Application Ref:	3/2025/0886			 <p>Ribble Valley Borough Council www.ribblevalley.gov.uk</p>
Date Inspected:	08/10/2025 (pre-application enquiry)	Site Notice:	06/02/2026	
Officer:	MC			
DELEGATED ITEM FILE REPORT:				APPROVAL

Development Description:	Proposed demolition of existing conservatory and the construction of a two-storey side extension.
Site Address/Location:	5 Stanley Court, Talbot Street, Chipping, PR3 2GE

PROPOSED PLANS & ELEVATIONS

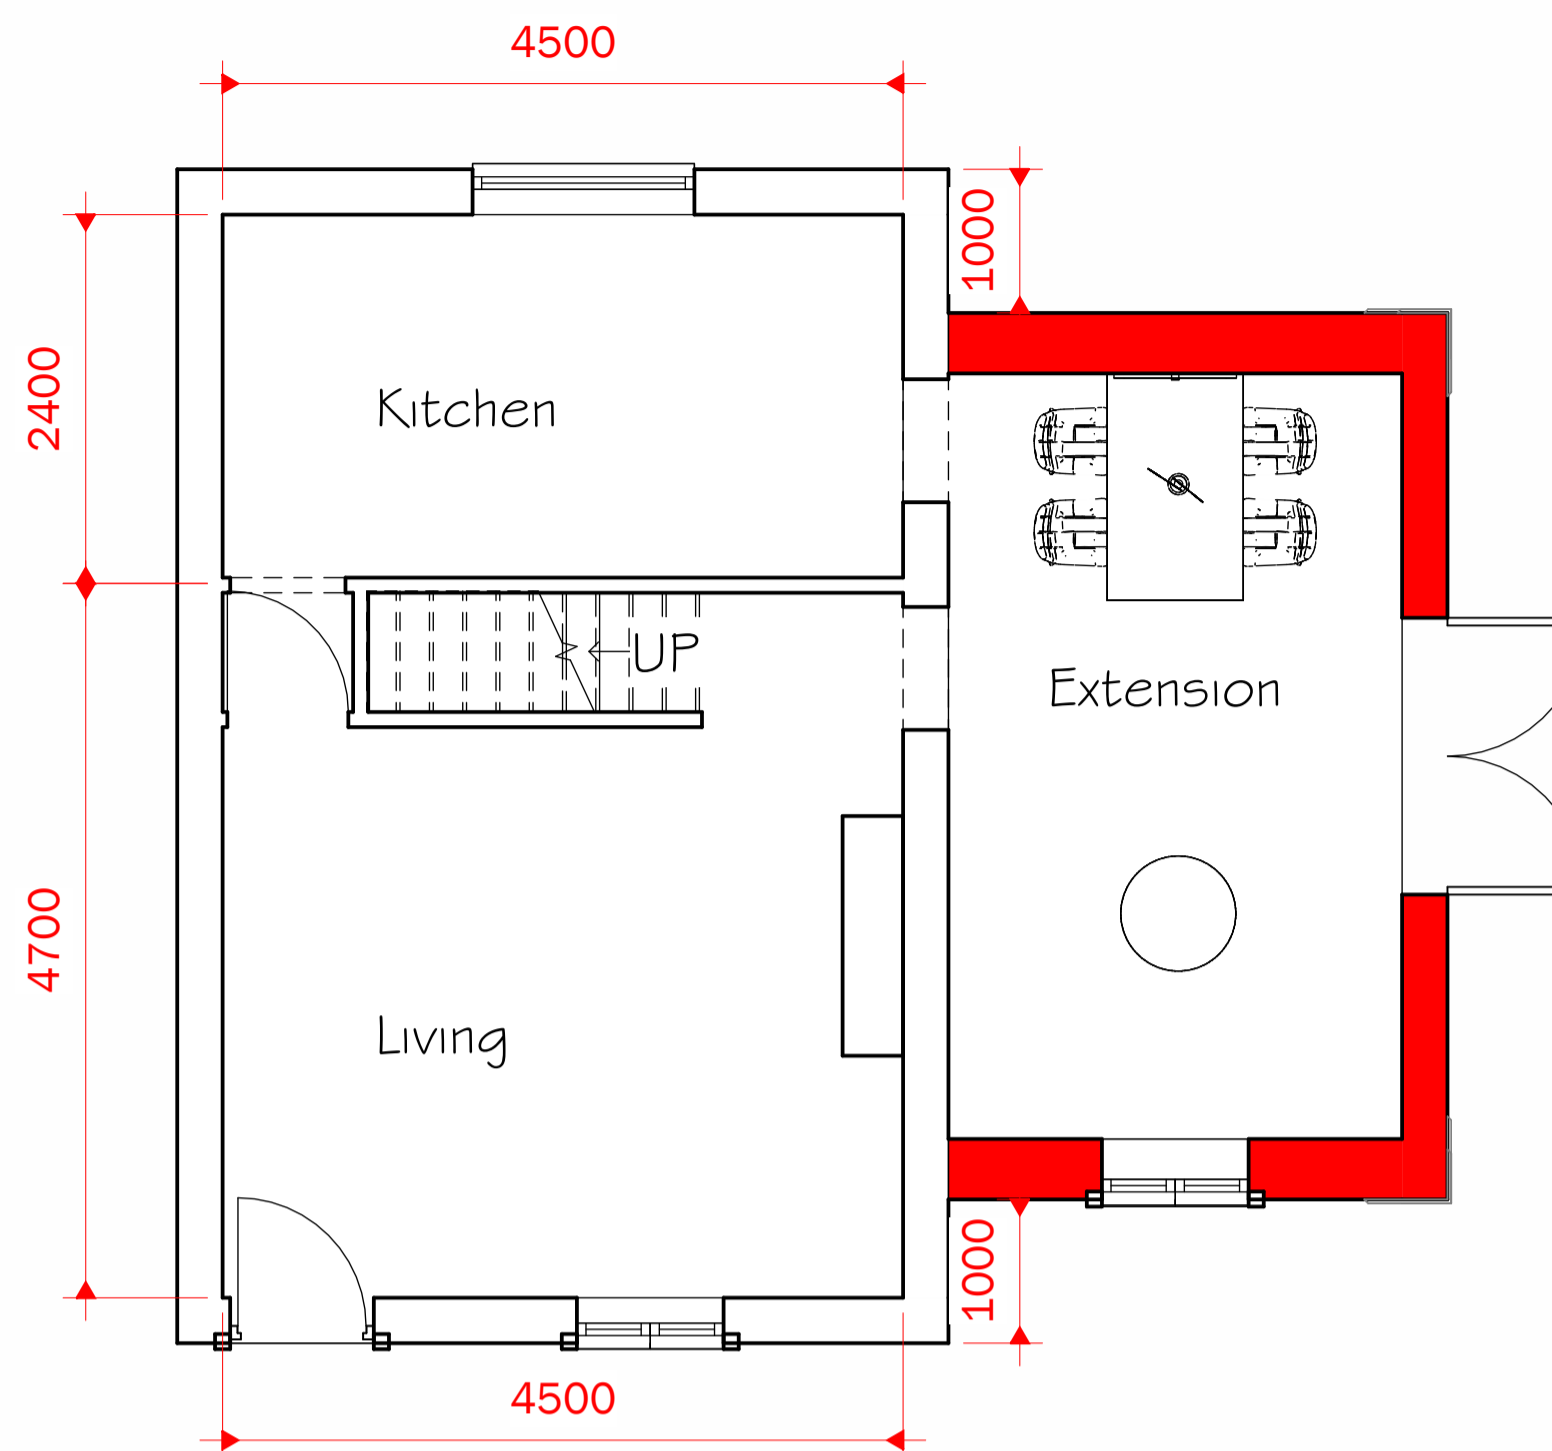
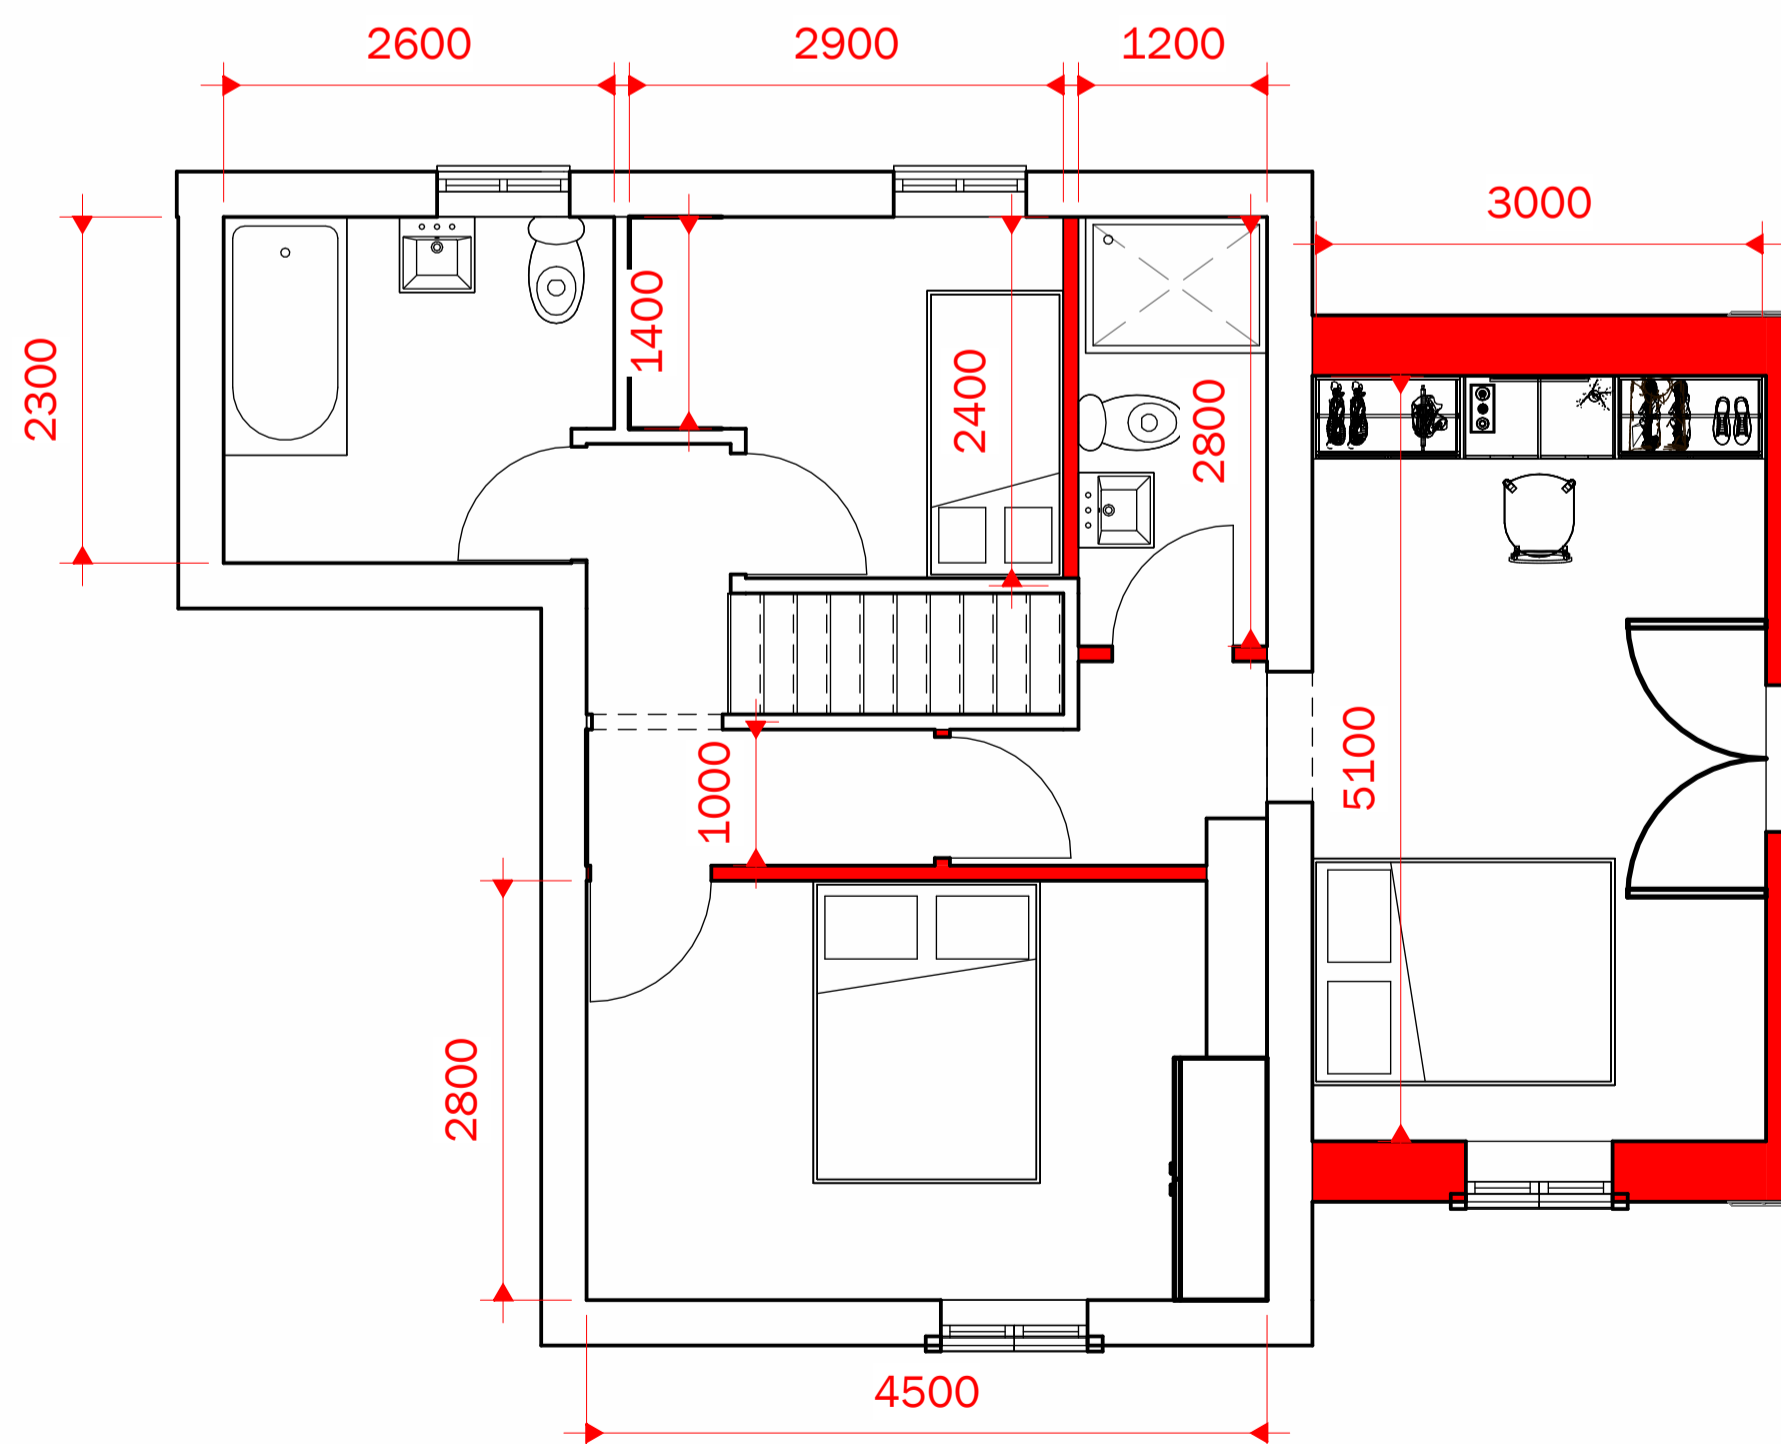
The design of the extension has been amended to reduce the width of the front elevation ground and first floor windows and amend the first floor Juliet balcony to the side elevation to a casement window.

It is noted that the front elevation windows would now match the existing in terms of the size and design which is considered to be more appropriate and would reduce the dominance of the extension. The first-floor side facing Juliet balcony has also now been removed from the scheme and would include a simple casement window which is considered to be more simplistic in appearance and appropriate to the character of the building.
